### **PLANNING APPLICATION CONSULTATION RESPONSE**

<b>Application Number:</b>	3/2023/0858
<b>Proposal:</b>	Retention of wedding marquee and raised decking to the west of the main built form of Stanley House until 31.12.2027.
<b>Location:</b>	Stanley House Preston New Road Mellor BB2 7NP

The Lead Local Flood Authority **maintains its objection** to the above application on the basis of:

#### **Objection 1 – Inadequate Surface Water Sustainable Drainage Strategy**

SOAKAWAY DRAINAGE STRATEGY PLAN

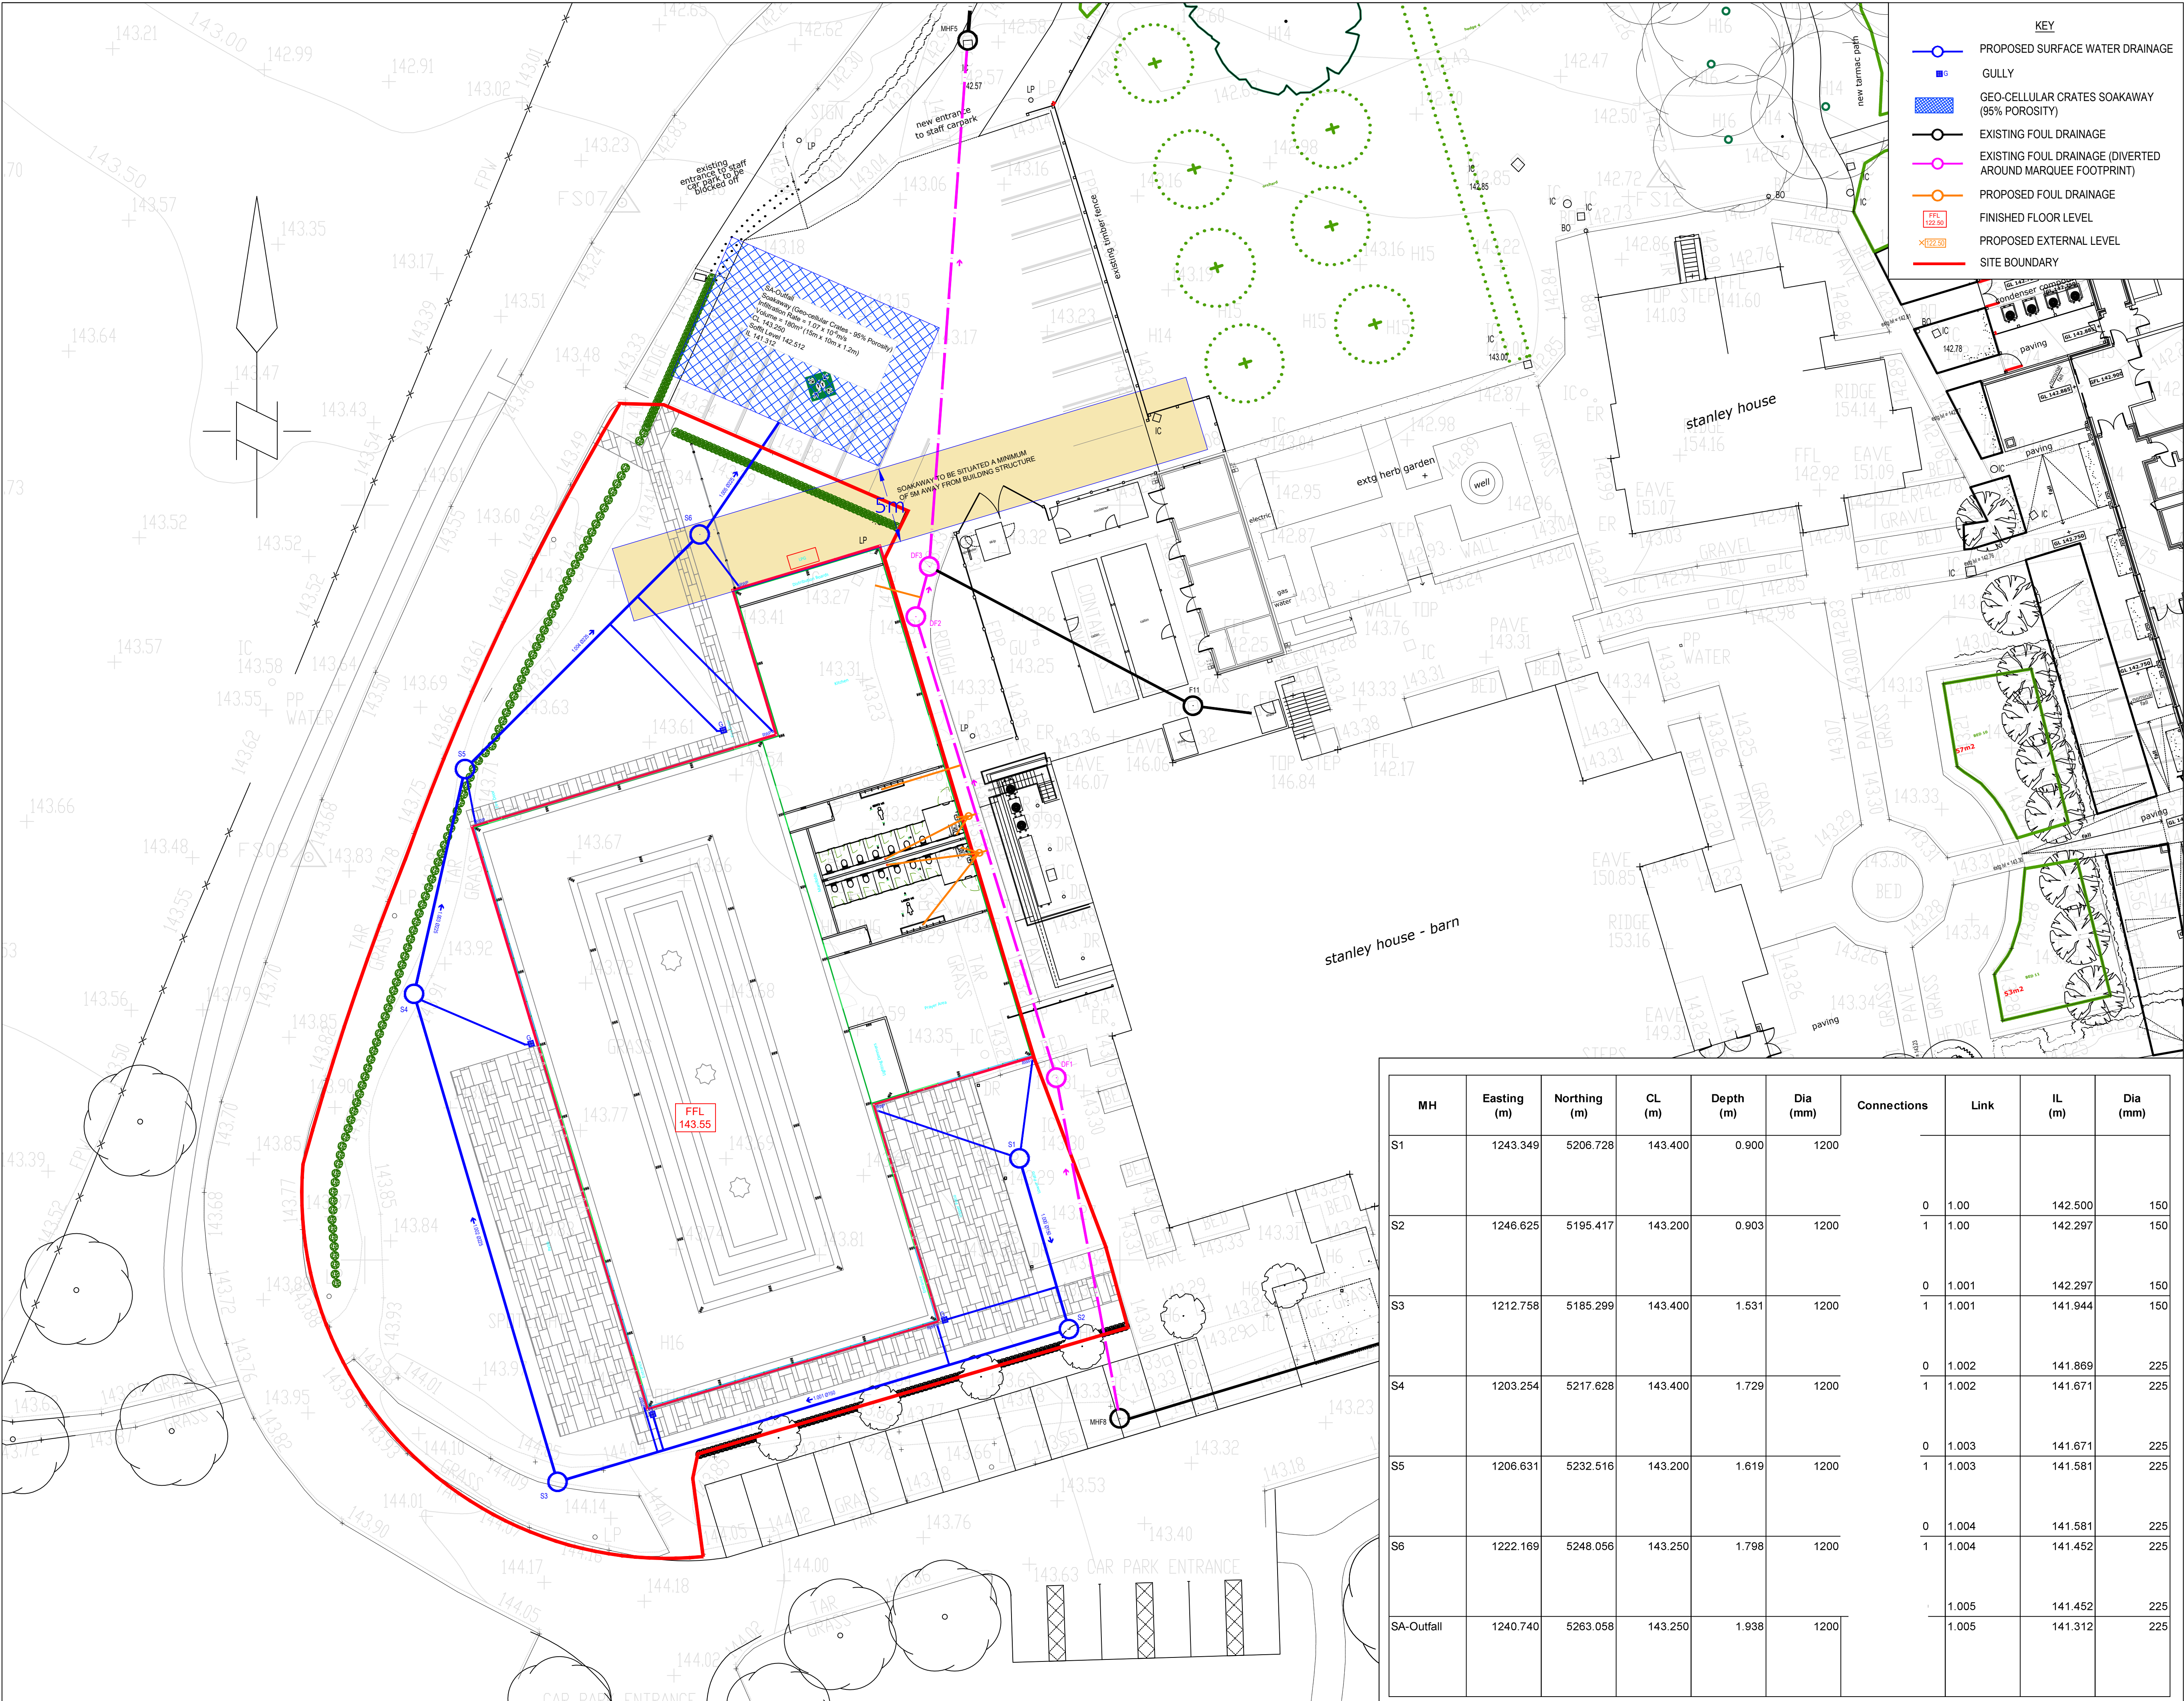
1. **Demonstrate the principle of development.** The proposed drainage strategy involves a soakaway to the northern area of the development, however, the soakaway tests provided demonstrate that infiltration is not viable in the trial pit locations or in accordance with parameters within section 25.3 of The SuDS Manual. Should no evidence be provided that appropriately demonstrates that infiltration is viable in the proposed soakaway location, then it may not be possible to drain the site, hence the Lead Local Flood Authority are currently unable to agree to the principle of development and recommend the refusal of planning permission, until evidence of acceptable infiltration testing, or robust evidence of a 'plan b' outfall location, has been submitted to and approved in writing by the Local Planning Authority.

Section 25.3 of The SuDS Manual states that 'The results of incomplete tests should not be extrapolated to obtain design values of infiltration rates. The head of water in the infiltration test should fall to less than 25% of the initial head of water. If this does not occur, the results should state that the infiltration rate cannot be determined. If other variations to the test method in Bettez (1996) be required, the test results sheet should clearly state what variations have been made to the test and why'.

In addition to this, should the applicant continue to explore the option of a soakaway, the applicant is expected to undertake infiltration testing in the area designated for any proposed soakaway.

You can overcome our objection by submitting information that covers the deficiencies highlighted above and demonstrates how surface water will be managed on-site, to satisfy Paragraphs 173 and 175 of the National Planning Policy Framework, the Planning Practice Guidance, and the Defra Technical Standards for Sustainable Drainage Systems. If this cannot be achieved we are likely to maintain our objection to the application. Production of this information will not in itself result in the removal of an objection.
